### **PLANNING APPLICATION CONSULTATION RESPONSE**

<b>Application Number:</b>	3/2025/0196
<b>Proposal:</b>	Outline planning application for up to 300 residential dwellings, associated access, rail station car park, green infrastructure and sustainable drainage systems (all matters reserved except for access).
<b>Location:</b>	Land off Longsight Road Langho bounded by the railway Northcote Park and Wildmans Farm,

#### **Lead Local Flood Authority Position**

The Lead Local Flood Authority has **no objection** to the above application subject to the inclusion of the following conditions, in consultation with the Lead Local Flood Authority:

APPENDIX 6

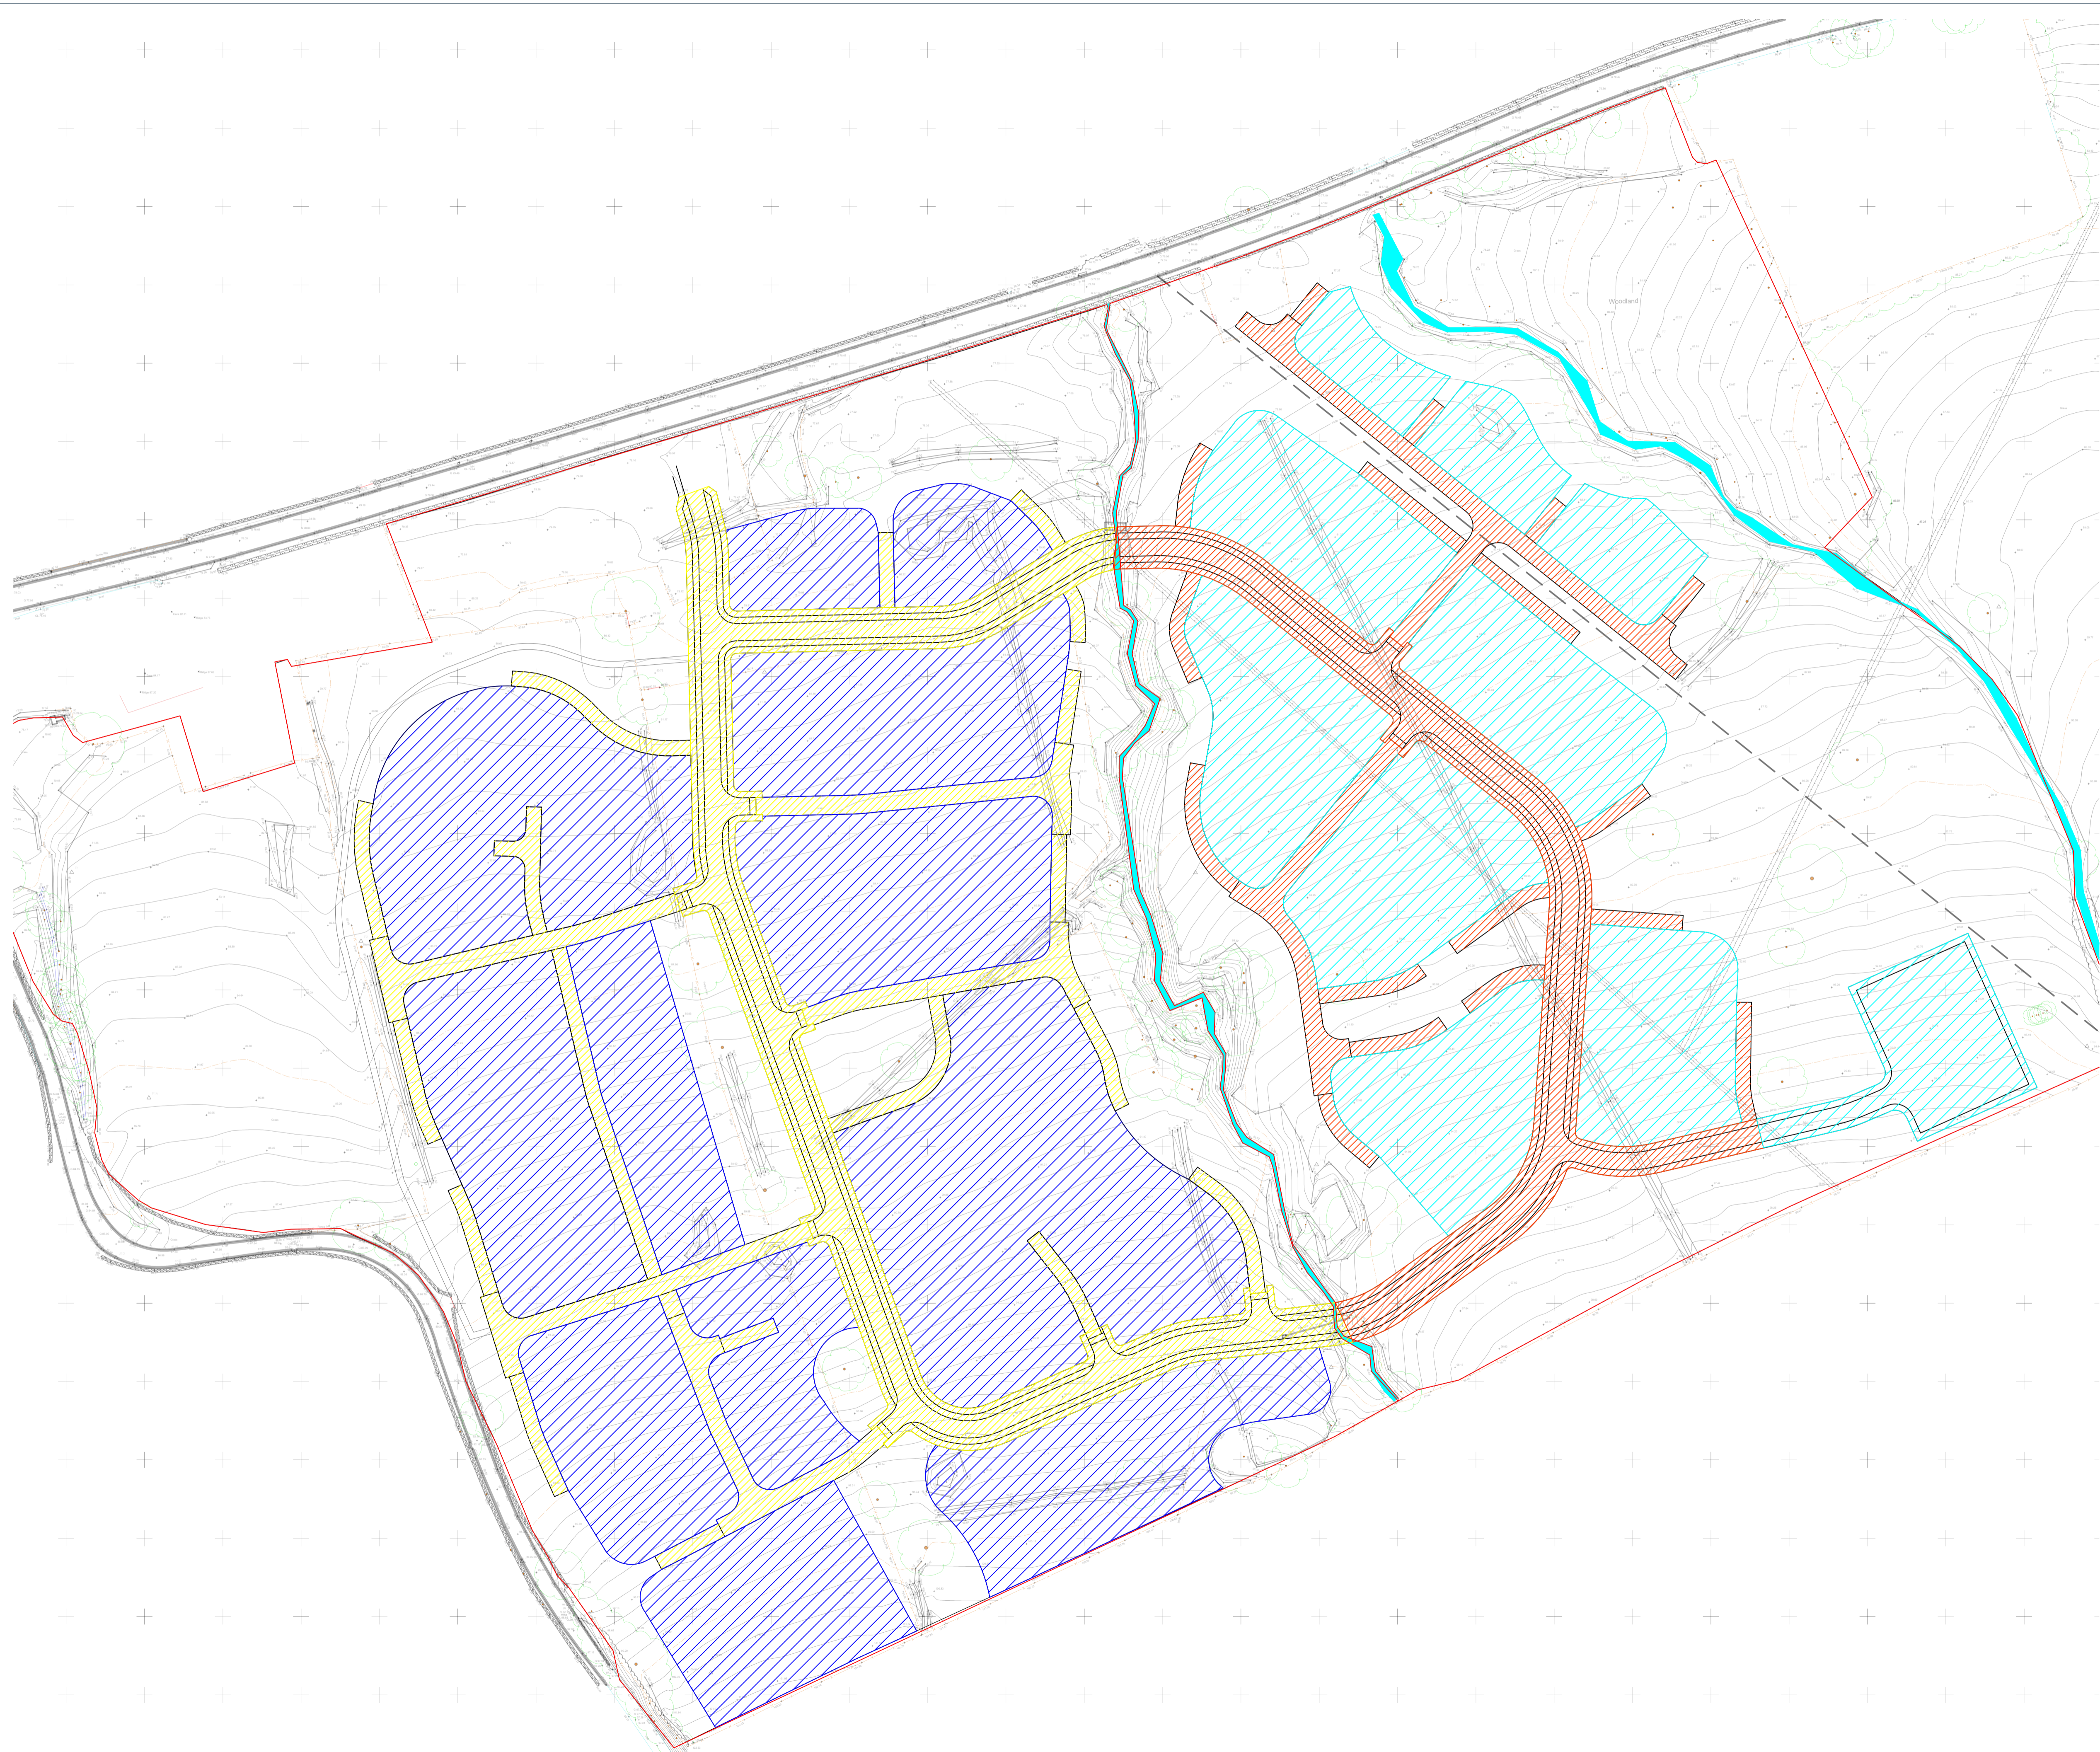
It is our understanding that the submitted drainage strategy sizes the SuDS based only on the impermeable area of the site, excluding the remaining permeable areas of the site, but calculates the discharge rate based on the full/developable site area.

The applicant has stated that infiltration is not possible on the proposed development and, therefore, while these areas, such as gardens, roadside verges and areas of public open space, may not be positively drained, they may contribute indirectly to the drainage system during extreme events.

The applicant must design their SuDS with an appropriate estimation of the area contributing to the drainage system, both permeable and impermeable, with evidence of this area provided through an appropriate contributing areas plan, or otherwise demonstrate how surface water runoff from non-drained areas will be managed without contributing to the drainage system and without increasing flood risk on or off-site.

The current failure to do so means the SuDS is likely undersized and, therefore, may contribute to increased flood risk on or off-site, contrary to the National Planning Policy Framework.

The Lead Local Flood Authority expects a volumetric runoff coefficient of 1 to be applied when modelling impermeable areas. An appropriate coefficient for permeable areas should be selected and justified by applicants based on factors including the site geology and soil type, site gradient, event size and antecedent conditions. For impermeable sites, for example, with clay geology, a coefficient of 1 could be applied to the permeable areas owing to the potential for these areas to contribute to the SuDS during extreme events. If using different parameters from those detailed, all applicants will be expected to provide robust evidence to justify their choices
